Lithgow Environment Group Inc.

The Director
Major Infrastructure Assessment
Department of Planning
GPO Box 39, SYDNEY NSW 2001

28 April 2014

**RE: Part 3A Modification 4 – Invincible Mine Extension (07_0127 MOD 4) and
Part 3A Modification 2 – Cullen Valley Mine Extension (DA 200-5-2003 MOD 2)**

Figure 13: Modification Layout – Including Areas of Highwall Mining

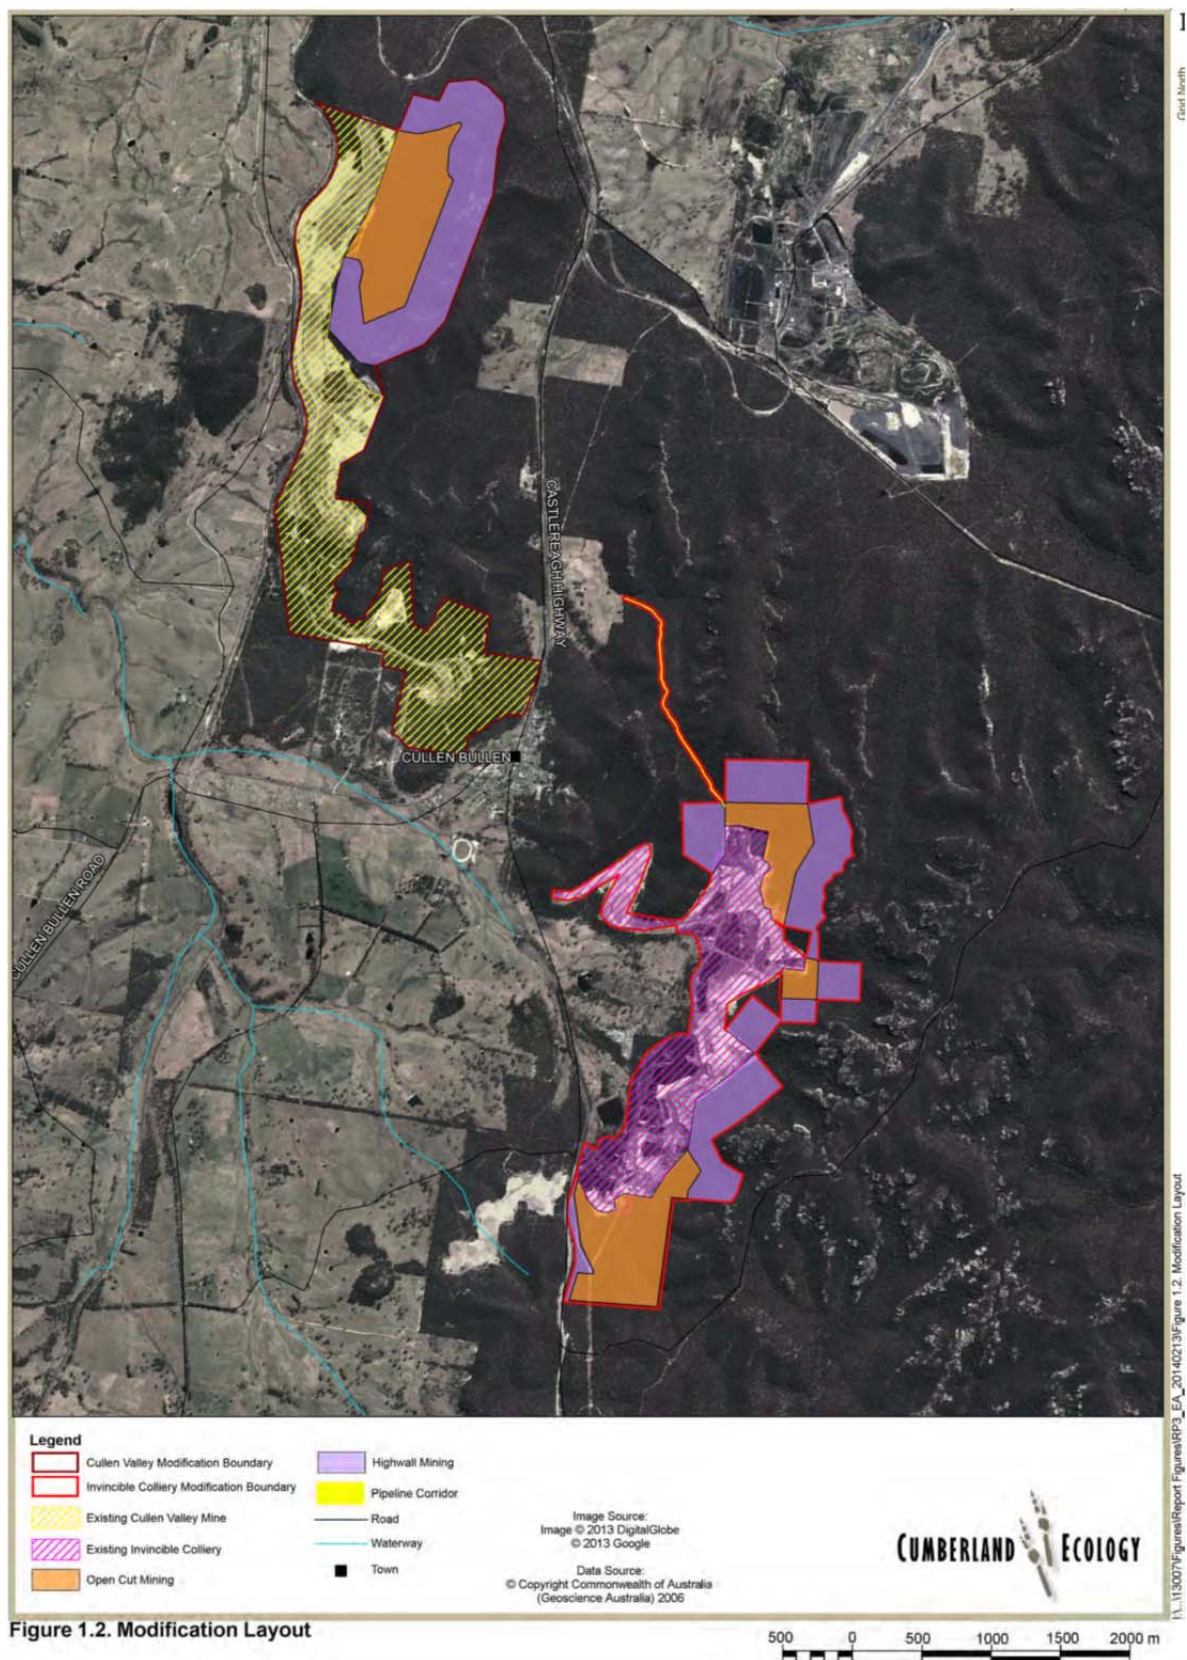
Yet **Figure 13** clearly shows three (3) areas of the Box Gum Woodland CEEC have been mapped within the orange or Open-cut Disturbance Boundary of the Invincible Mine Extension (07_0127 MOD 4).
